| Application Ref: | 3/2021/0112 |  <div>Ribble Valley Borough Council</div> <div>www.ribblevalley.gov.uk</div> | |
| DELEGATED ITEM FILE REPORT: | | Decision | REFUSE |

Proposed Dwelling
EXISTING SITE LAYOUT

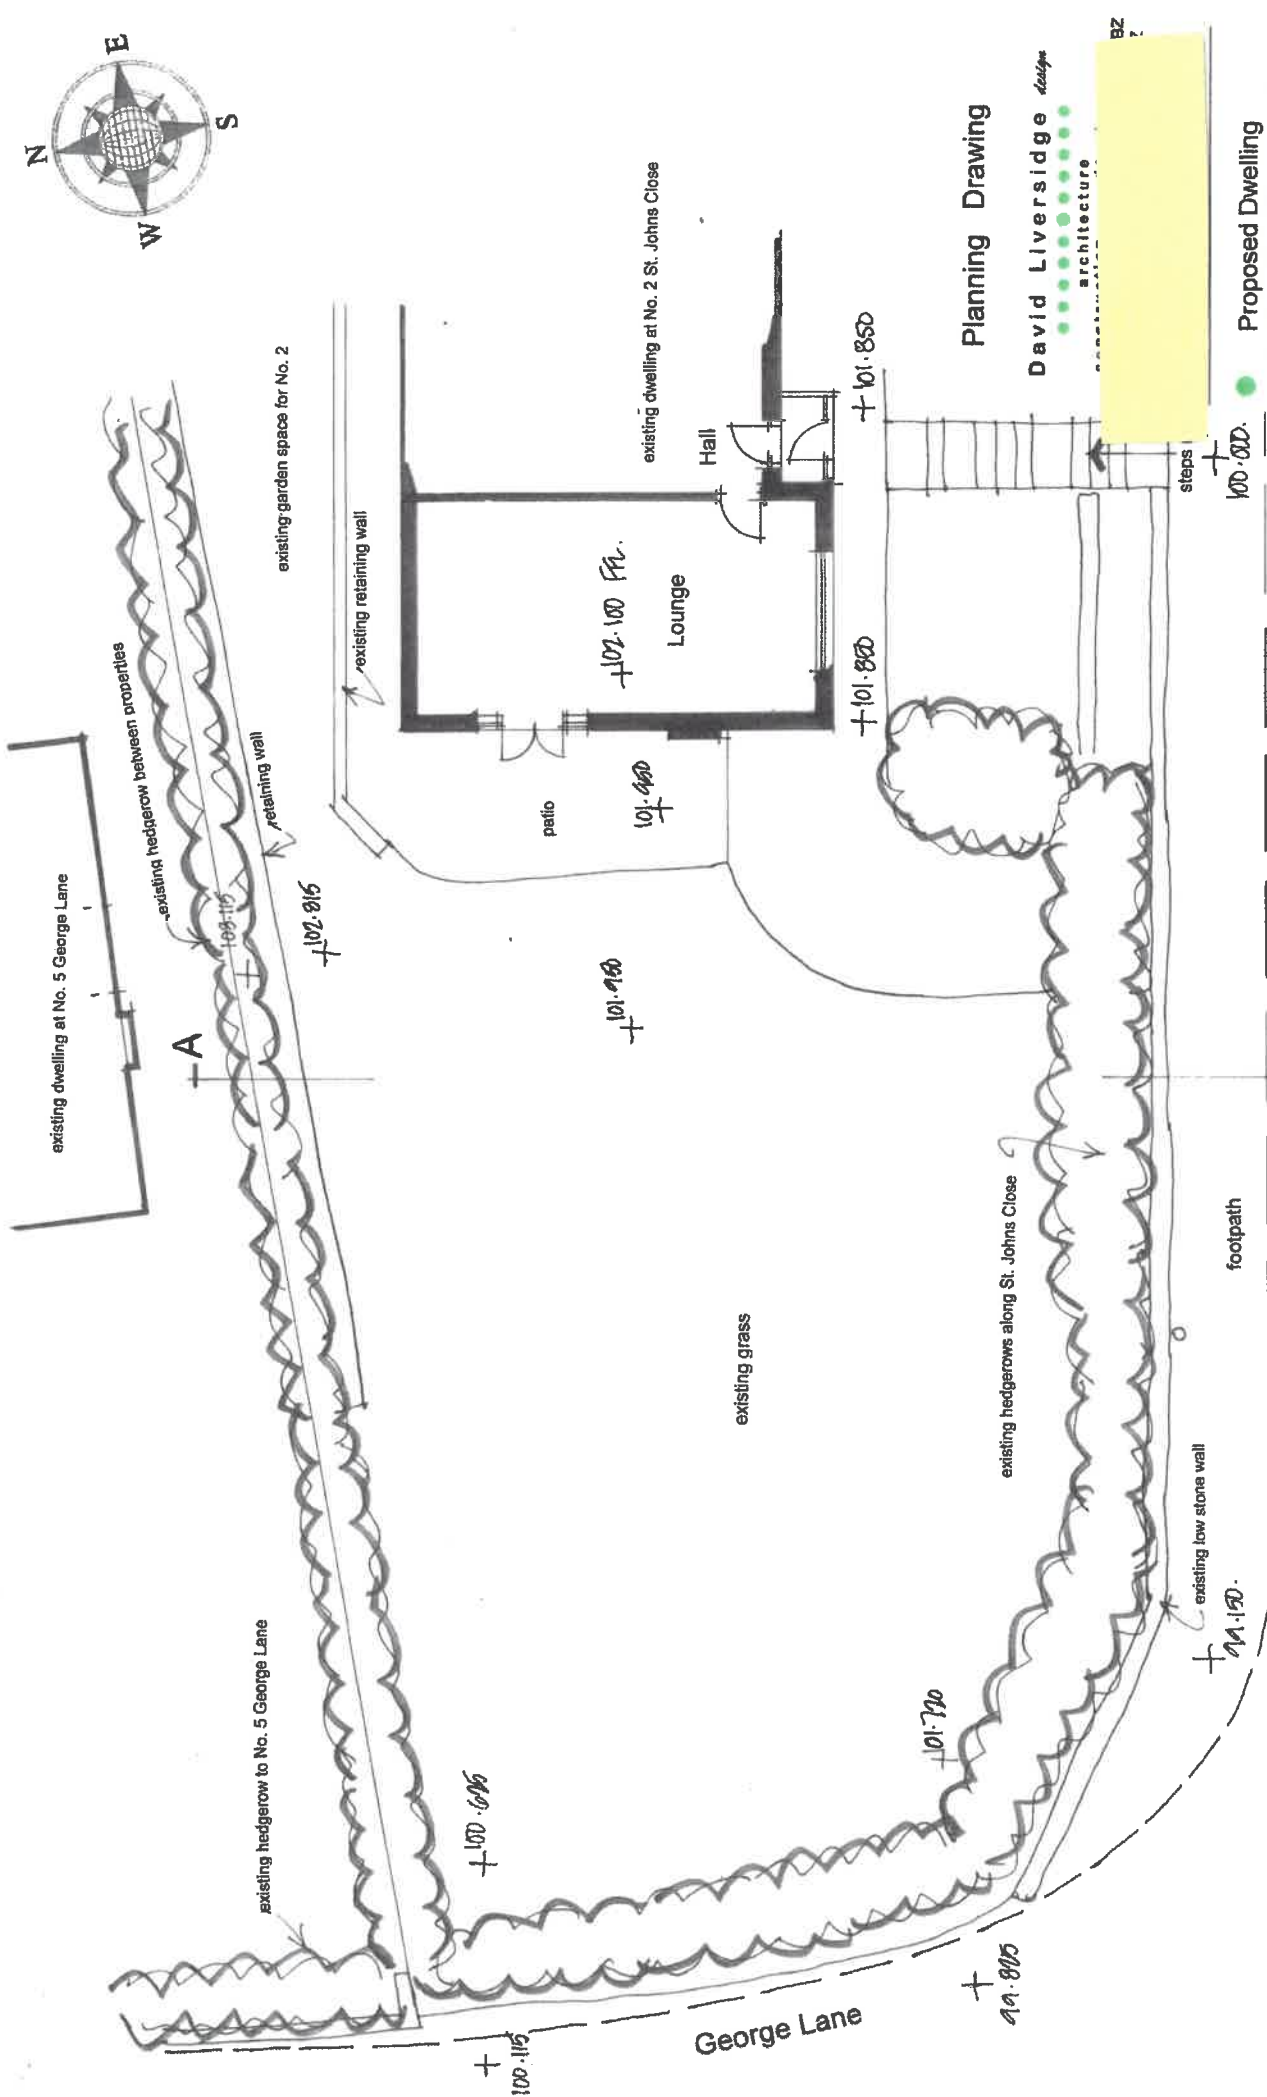
Similarly, the side elevation of number 2 St John's Close faces the rear of the proposed dwelling and has patio doors directly facing the rear elevation of the property as well as a first floor bedroom window. The two properties will be 1.8 metres apart at the nearest point and 3 metres at the further point.

The new dwelling will abut the boundary fence to the side and rear and most of the front garden will be taken up by the driveway. It will also significantly reduce the private amenity space for the parent property.

Furthermore, the mature boundary hedge will be removed to form a new access and expanses of hardstanding close to a prominent corner which will further detract from the appearance of the street scene.

The proposal includes a new access onto George Lane, located on a steeply sloping and curved section of the road close to a junction. LCC highways have raised an objection to the proposal due to inadequate visibility at this junction and it has not been demonstrated that adequate visibility could be achieved or that this council be achieved within land that is under the control of the applicant.

Proposed Dwelling  
DWELLING PLANS

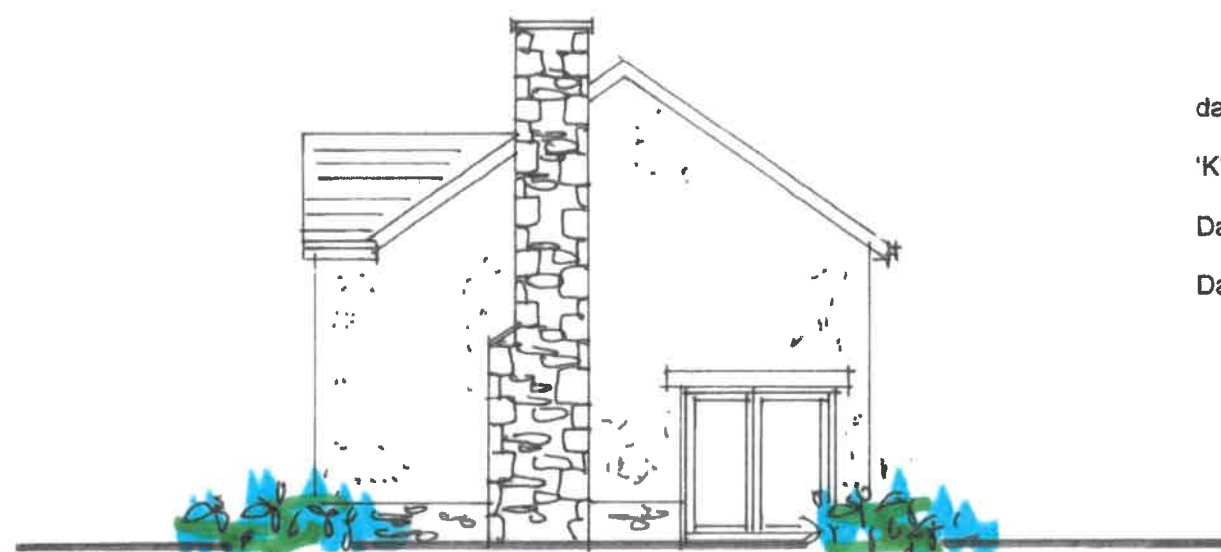
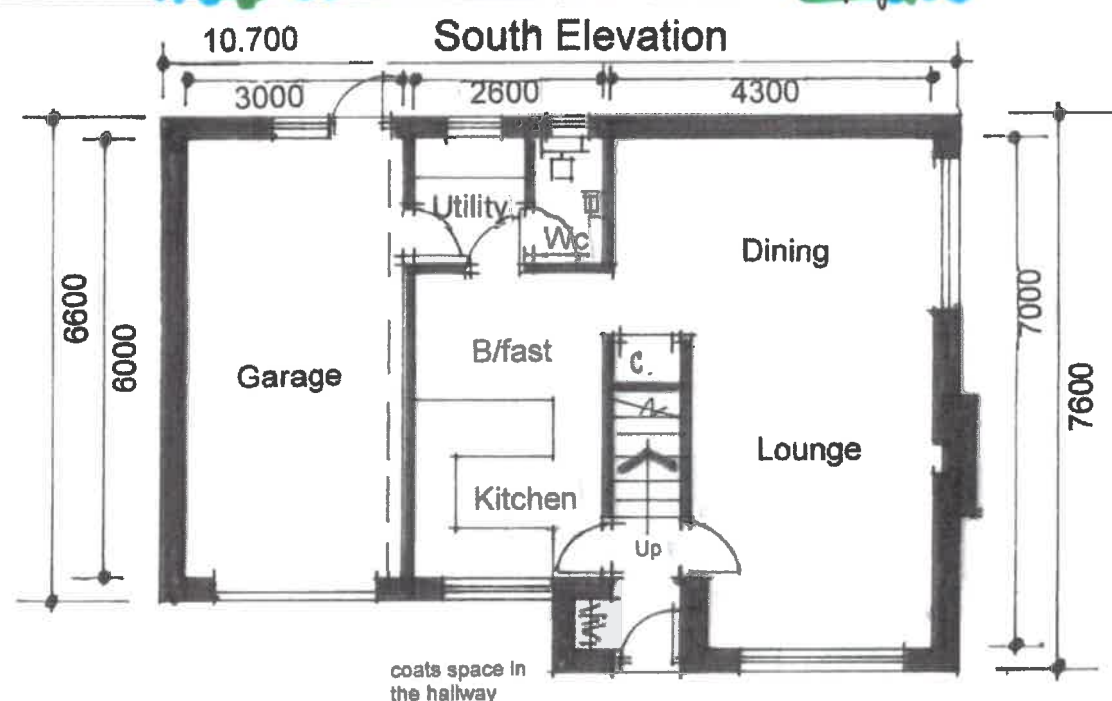
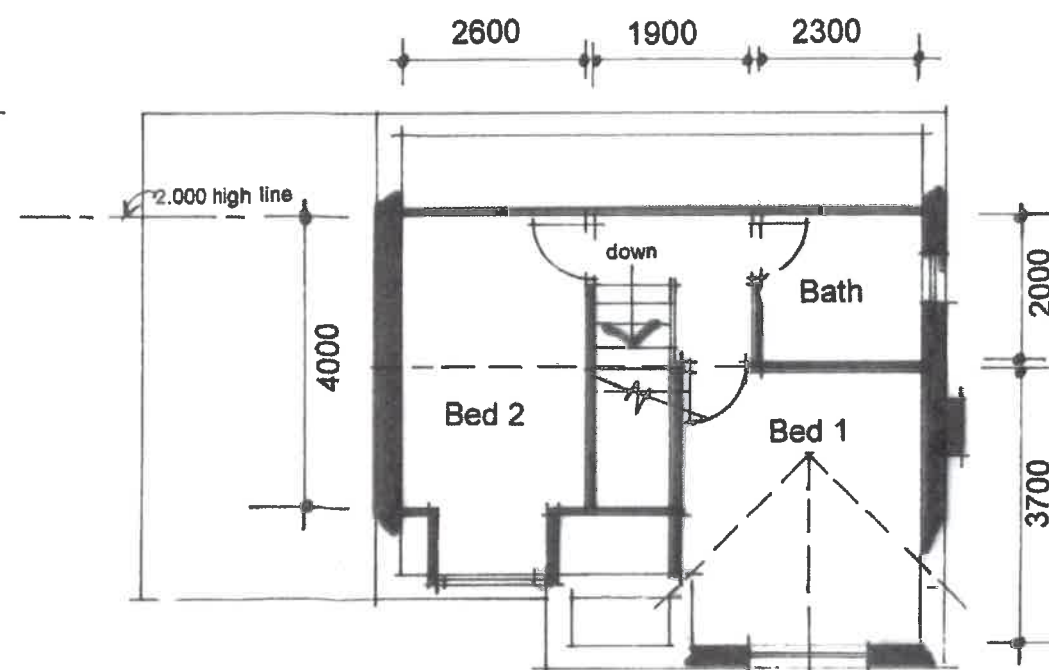
Number 5 George Lane has a window facing directly onto the site which appears to serve a bedroom, the side wall of the proposed dwelling would be located 3 metres away.

There is boundary screening proposed which would prevent direct overlooking between habitable room windows at ground floor and the elevations facing the surrounding properties have no habitable room windows which will overlook. However it is still considered to be poorly related to neighbouring properties due to the cramped nature of the development and will have an oppressive impact.
